**From:** Amanda Scholes on behalf of Planning.Responses  
**Sent:** 01 December 2021 09:50  
**To:** Planning Scanning  
**Subject:** FW: Planning Re-Consultation on: Y/156/21/DOC

**Application No:** Y/156/21/DOC  
**Registered:** 3rd November 2021  
**Site Address:** Land East of Drove Lane Yapton BN18 0EB

**Description of Works:** Approval of details reserved by condition imposed under Y/92/17/OUT relating to conditions 4-phasing for construction of dwellings & associated highways & public areas, 9-surface water drainage, 16-Construction Management Plan, 21-Travel Plan, 22-energy conversation, on site energy renewable devices & 25-electric vehicle charging strategy.

I am able to inform you that I have received an amendment to the above application dated 23rd November 2021 relating to: Amended Drainage Plans (at Applicant request)

Drawn	Date	Checked	Date	Approved	Date
SM	07.2020				
Scale	NTS	Orig Size	A1	Dimensions	Metres
Project No.	133647	Drawing File	PLN_1_4101 Typical SUDs details.dwg		
Drawing No.	PLN_1_4103			Rev.	G

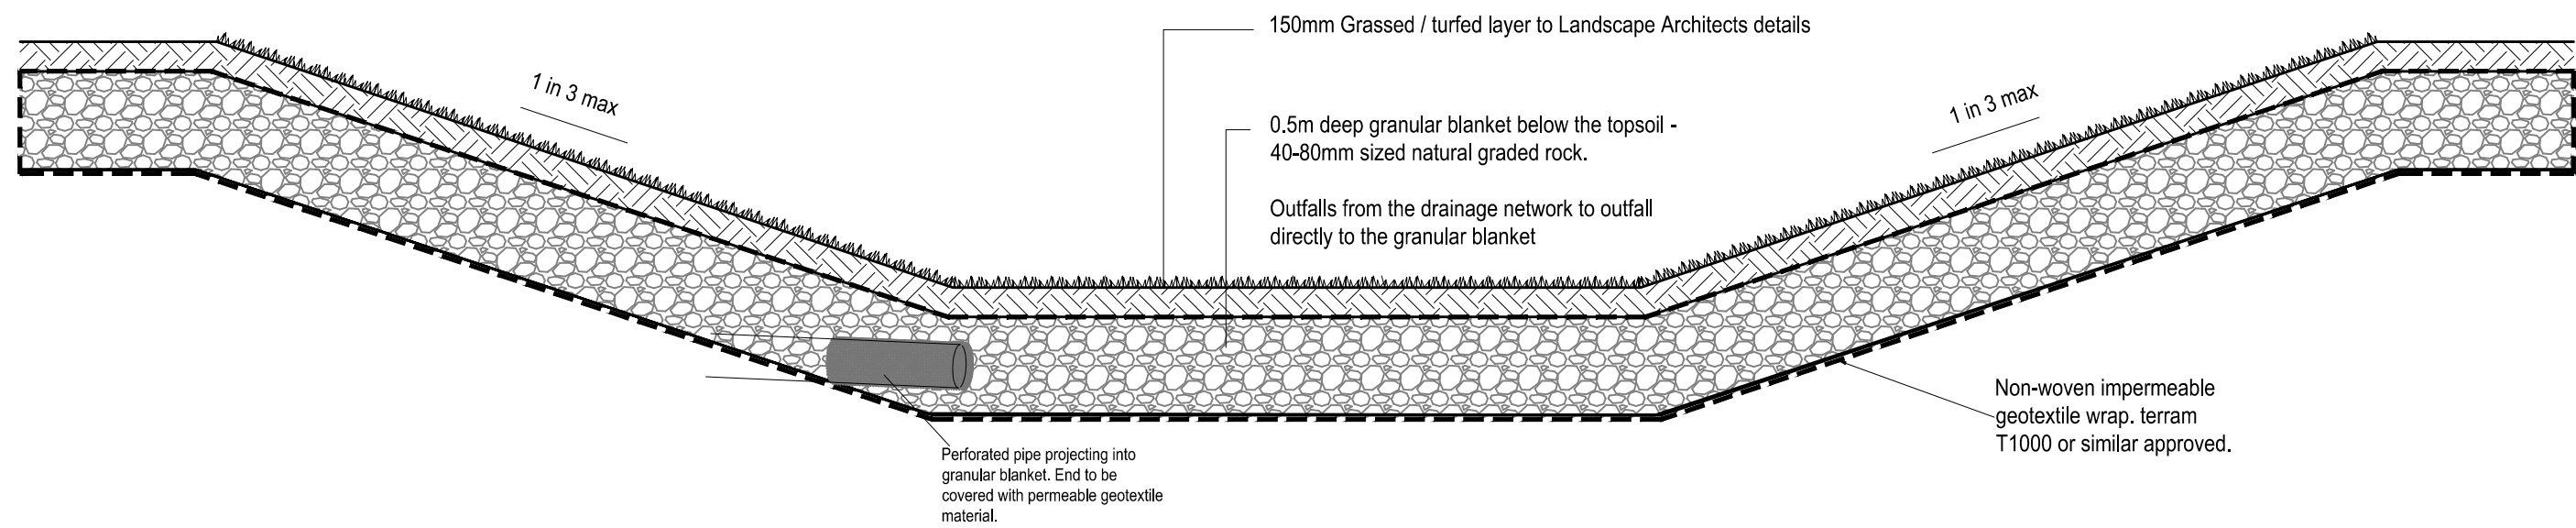
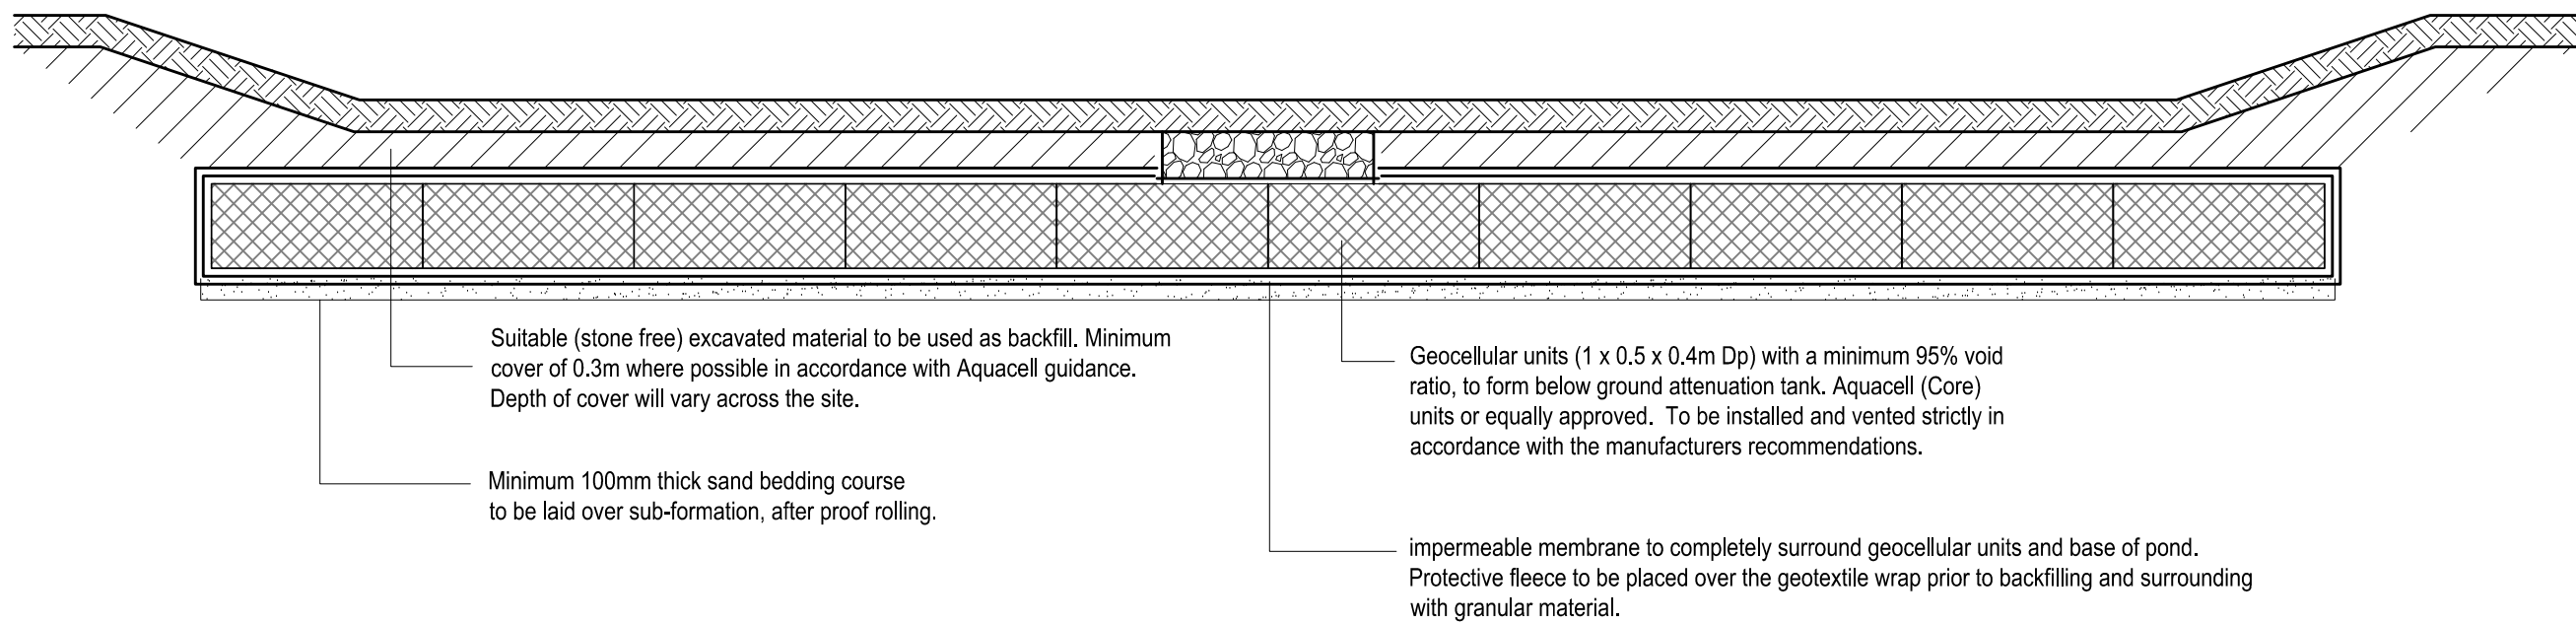
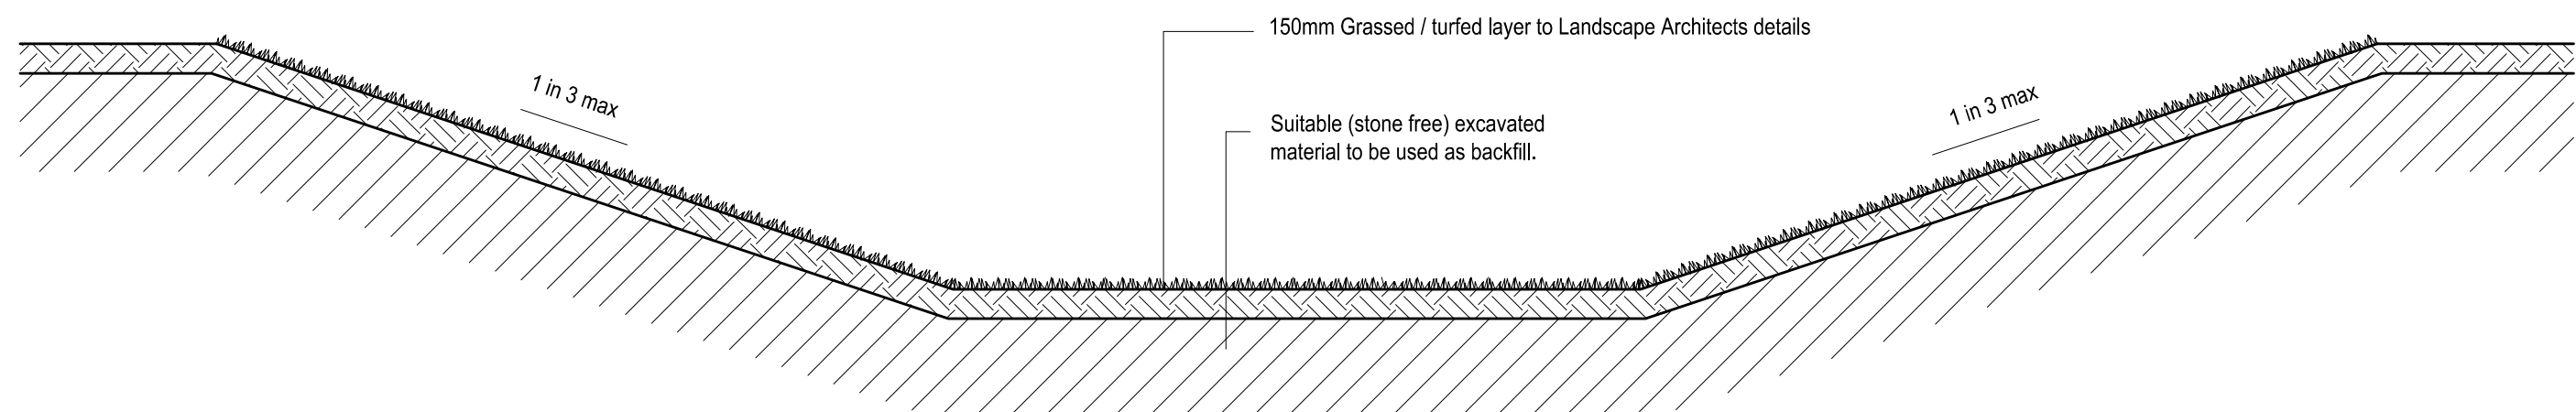
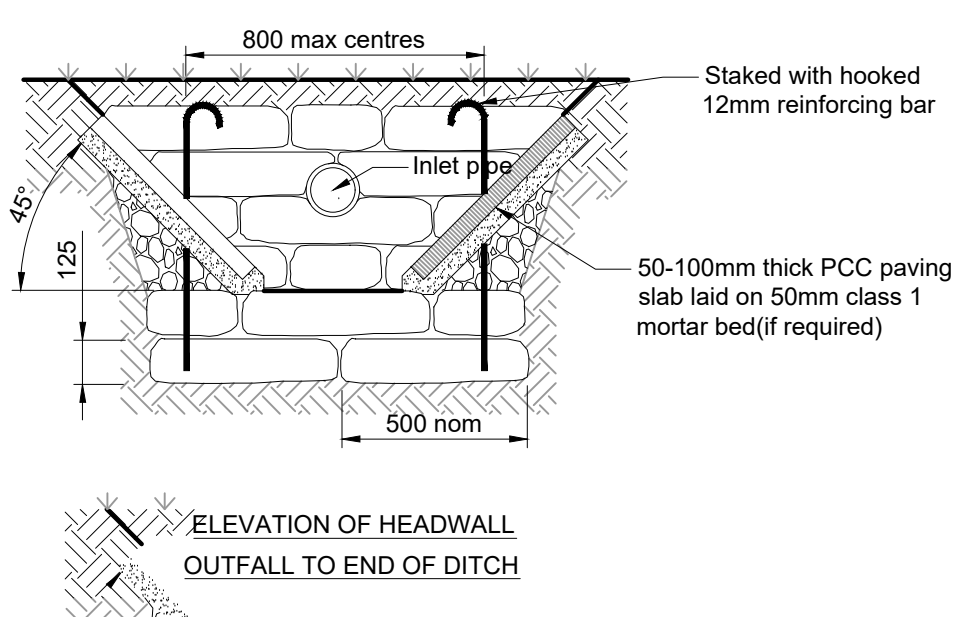
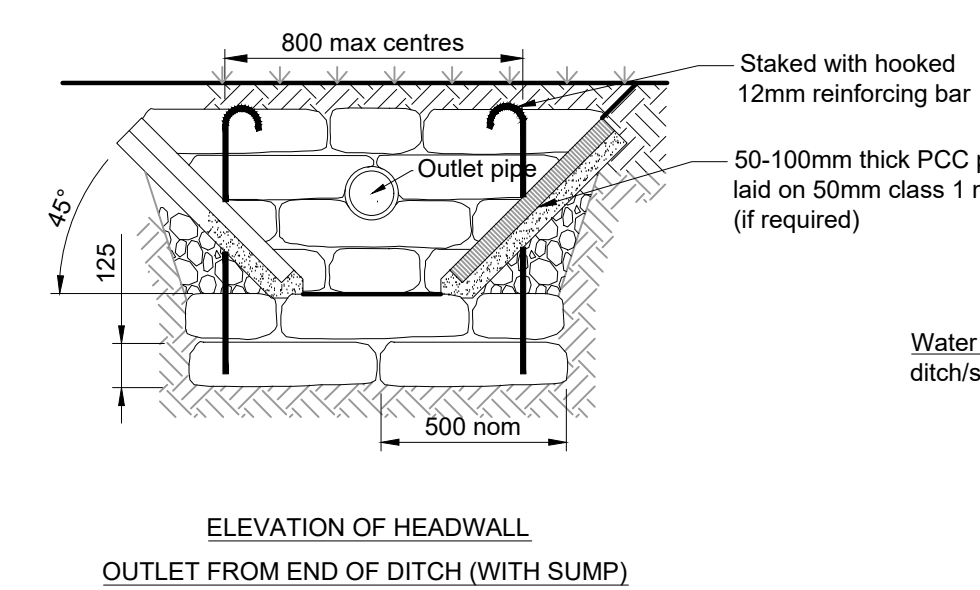
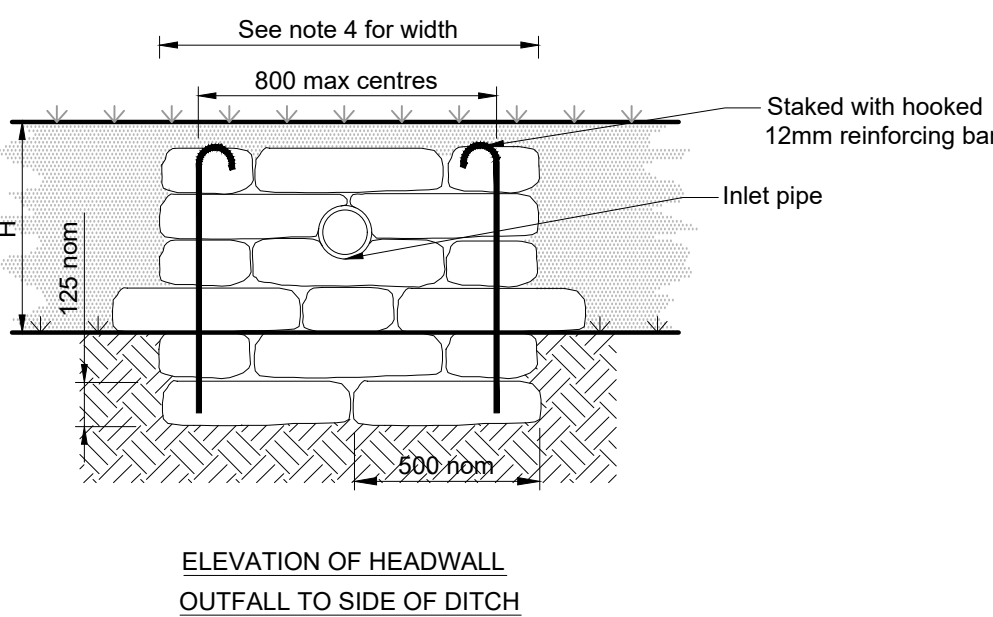
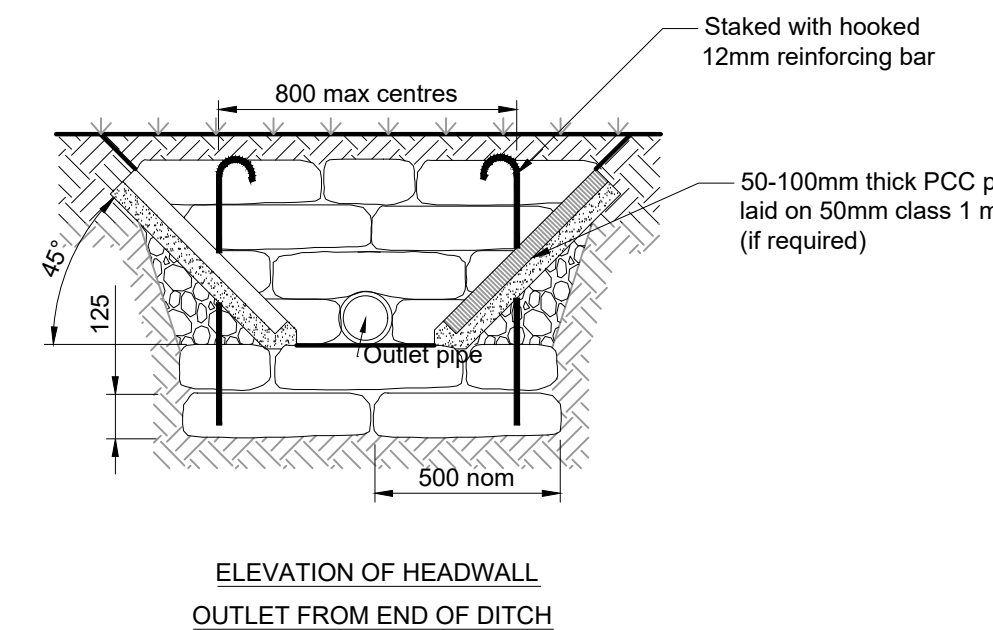
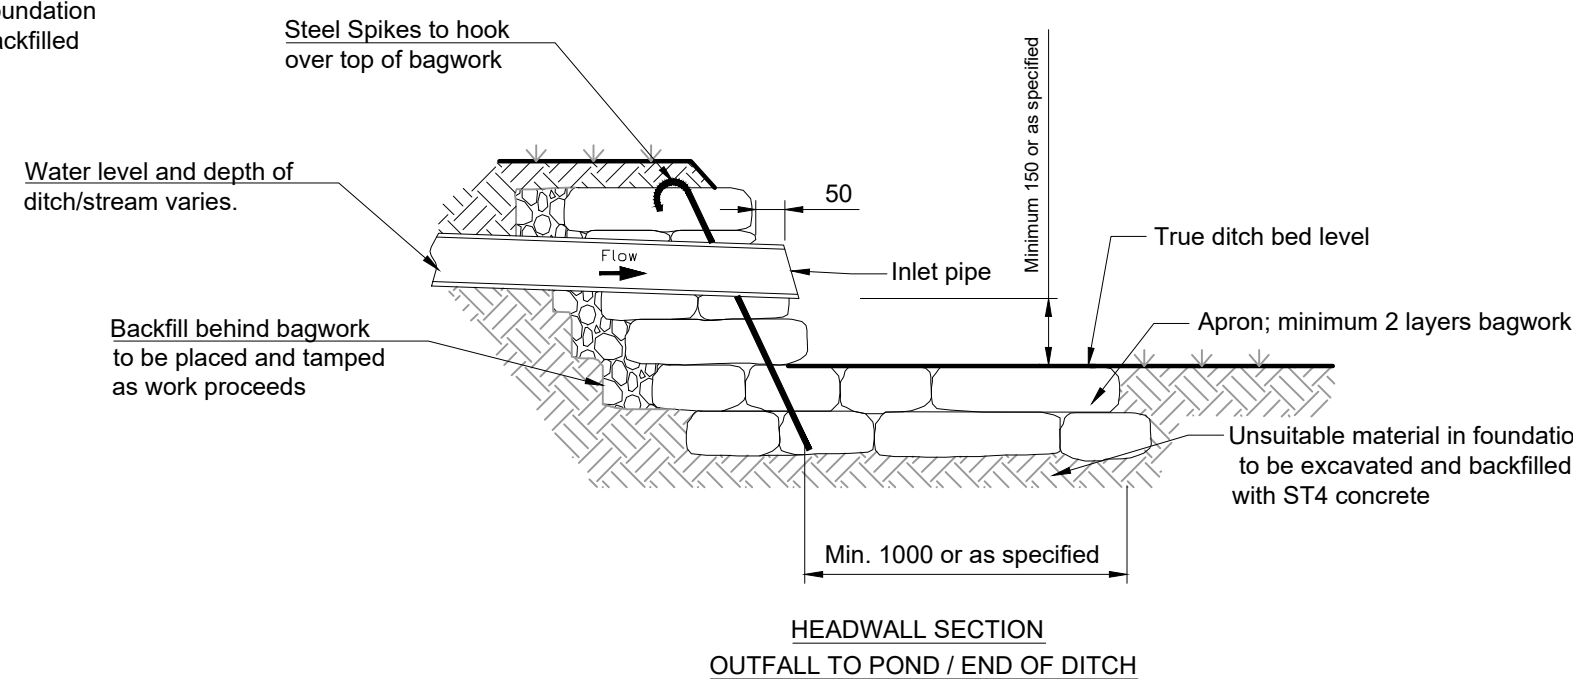
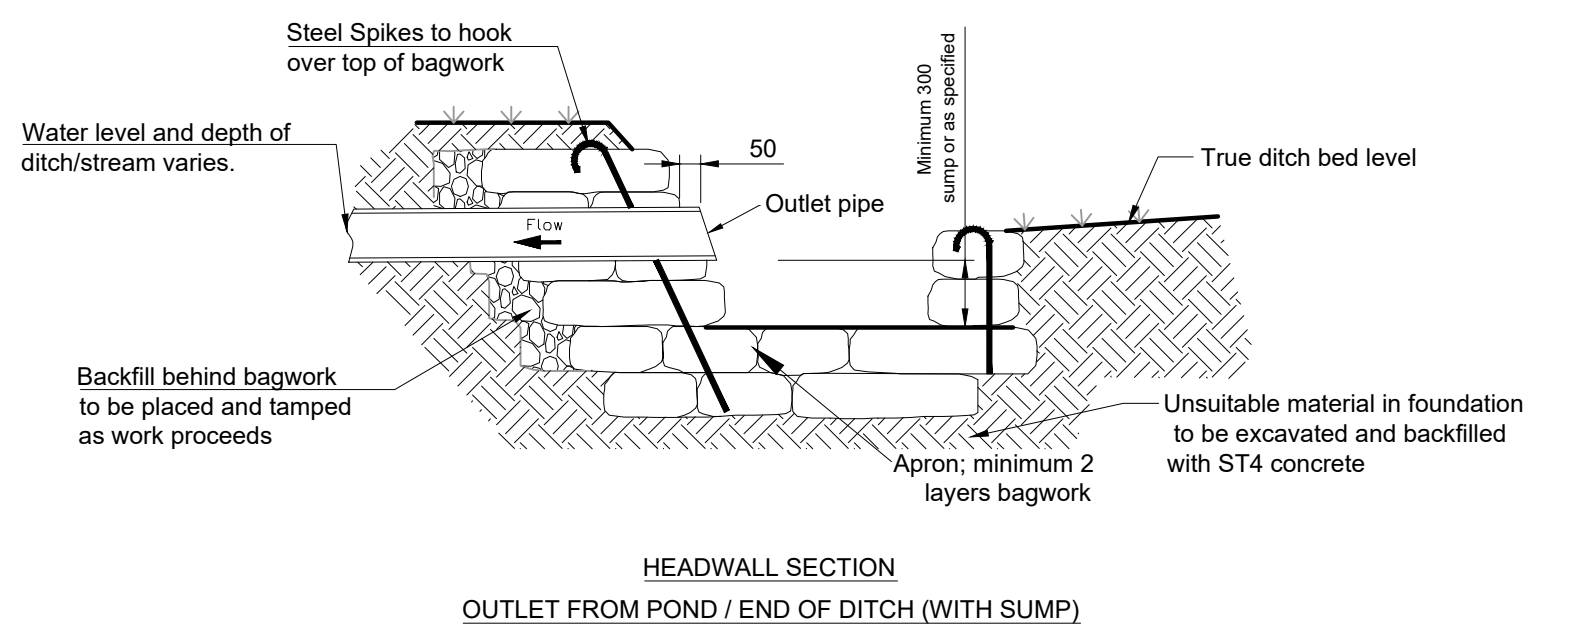
1. Suds detail sheet appears to detail and list features which are to be lined with an impermeable liner, contrary to the statement provided. Please confirm whether all features below peak groundwater level are to be impermeably lined.

8. Flotation calculations need to be supplied to support design of features which are below groundwater level and require lining.

14. Catchpits must be provided upstream of connections into permeable paving sub-base.
15. Pond 5 appears to be bunded. Please provide further details, i.e. crest width and slope on landward side. Pond 6 and 7 also appear to be bunded, same request applies.
